**Office of  
Environment  
& Heritage**

Your reference: 10-0204 MOD 2  
Our reference: DOC14/21410  
Contact: Anne Killick, 4908 6802

**RE: MODIFICATION REQUEST – CATHERINE HILL BAY AND GWANDALAN RESIDENTIAL SUBDIVISION (MP10-0204 MOD 2)**

Image 1: Location of section of road 23 proposed to be deleted.

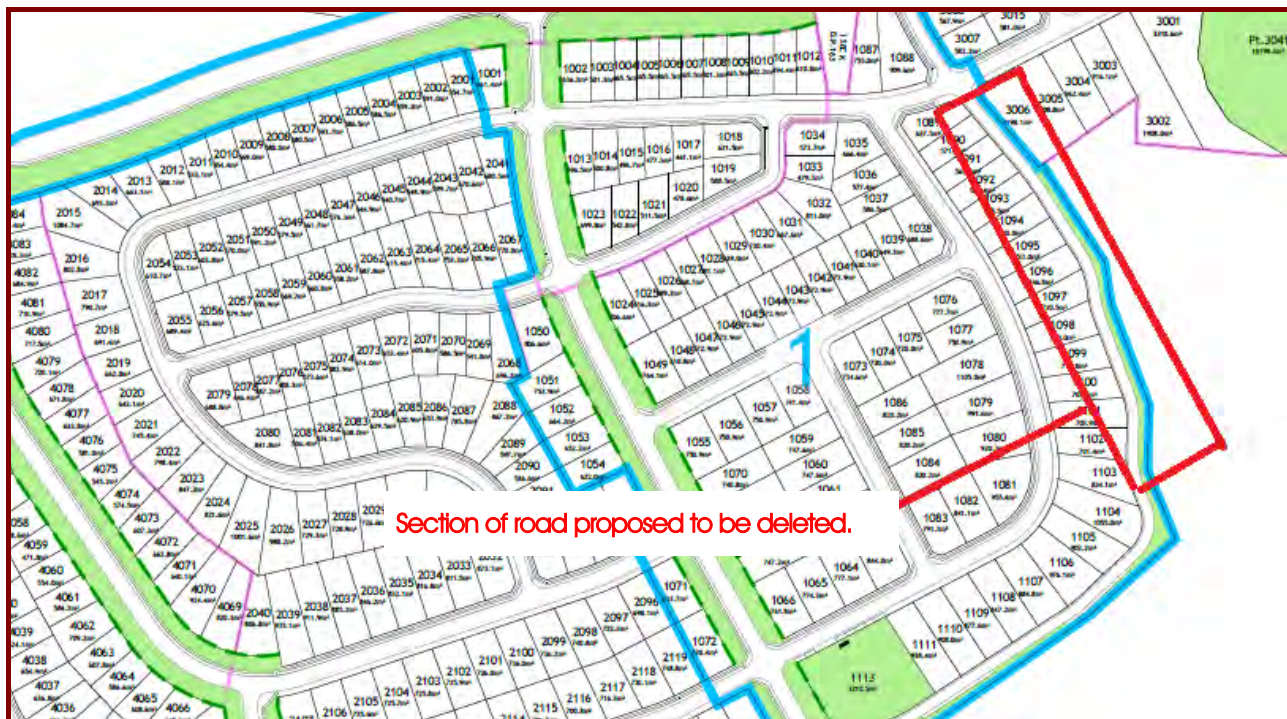
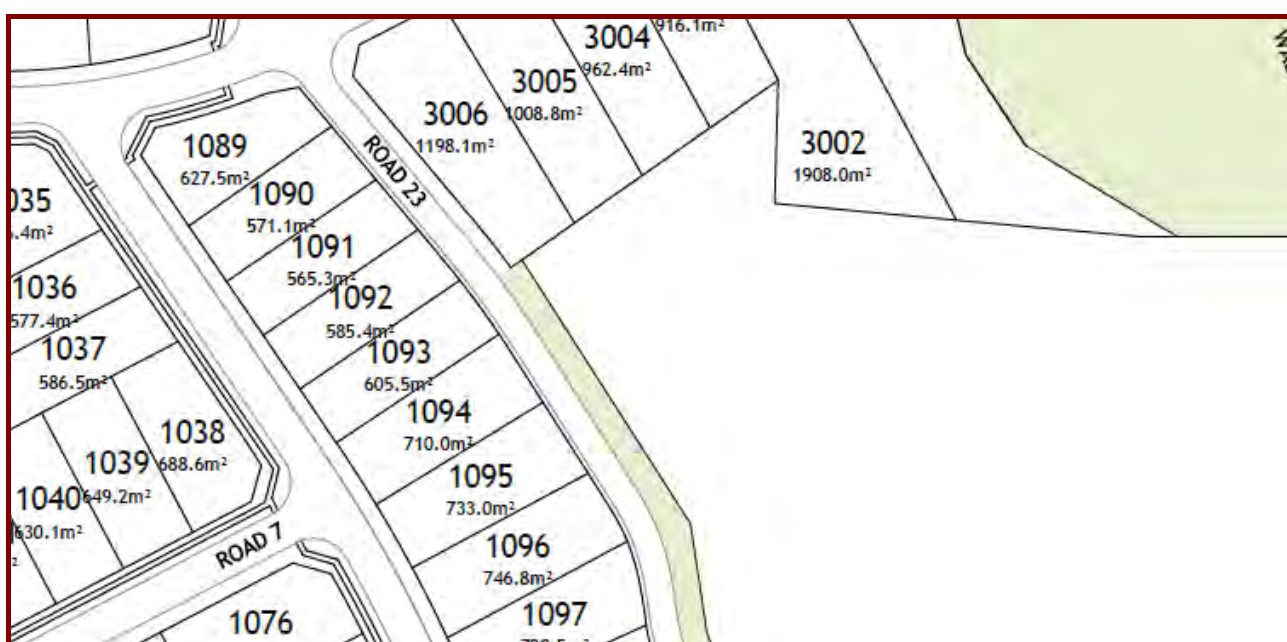
Given this, while OEH's preference is for the use of perimeter roads for areas directly adjoining NPWS reserve system, in this circumstance OEH does not object to the proposed removal of part of the perimeter road by 'deleting all of Road 23 from Lot 1101 north'.

Image 4: Extent of fill on adjoining land required to build Road 23 as approved.

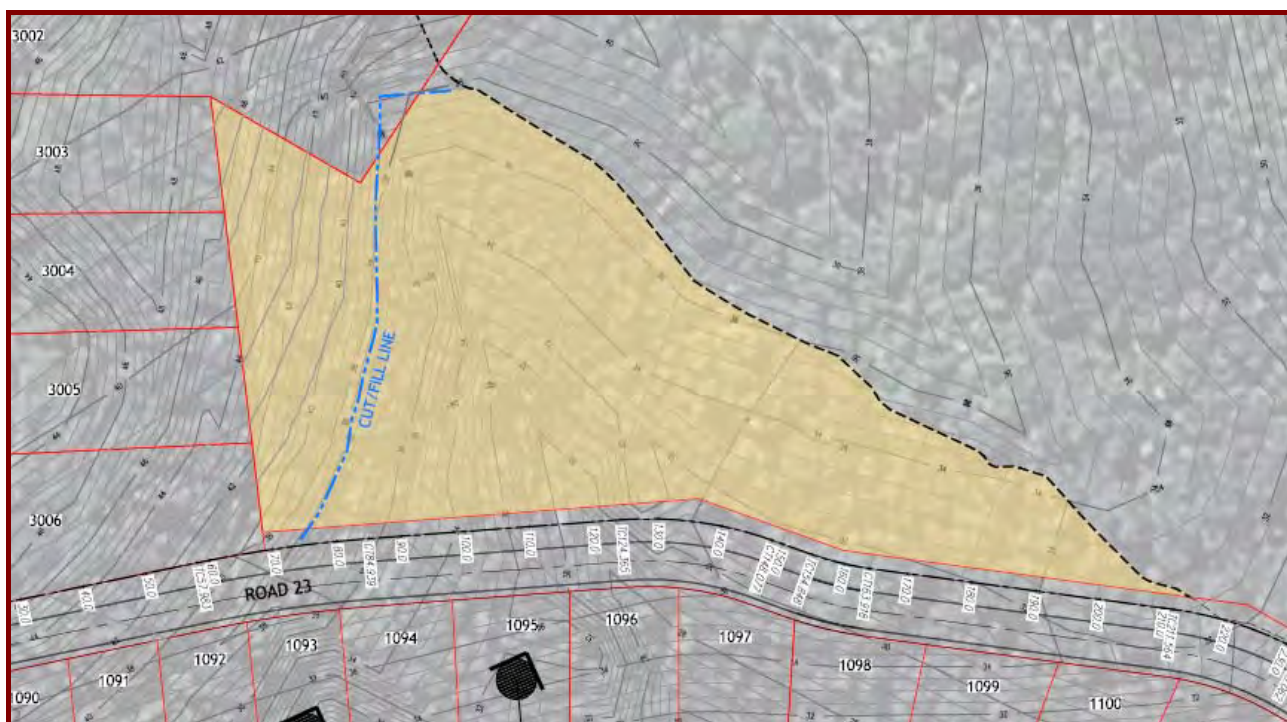
No encroachment into the adjoining Munmorah State Conservation Area (SCA) will be supported. This means that the retaining wall and fill requirements described on page 8 of the 'Application for Modification of Major Project Approval 10-0204' (ADW Johnson, January 2014) and the proposal for these to encroach into the SCA will not be supported or authorised by OEH.
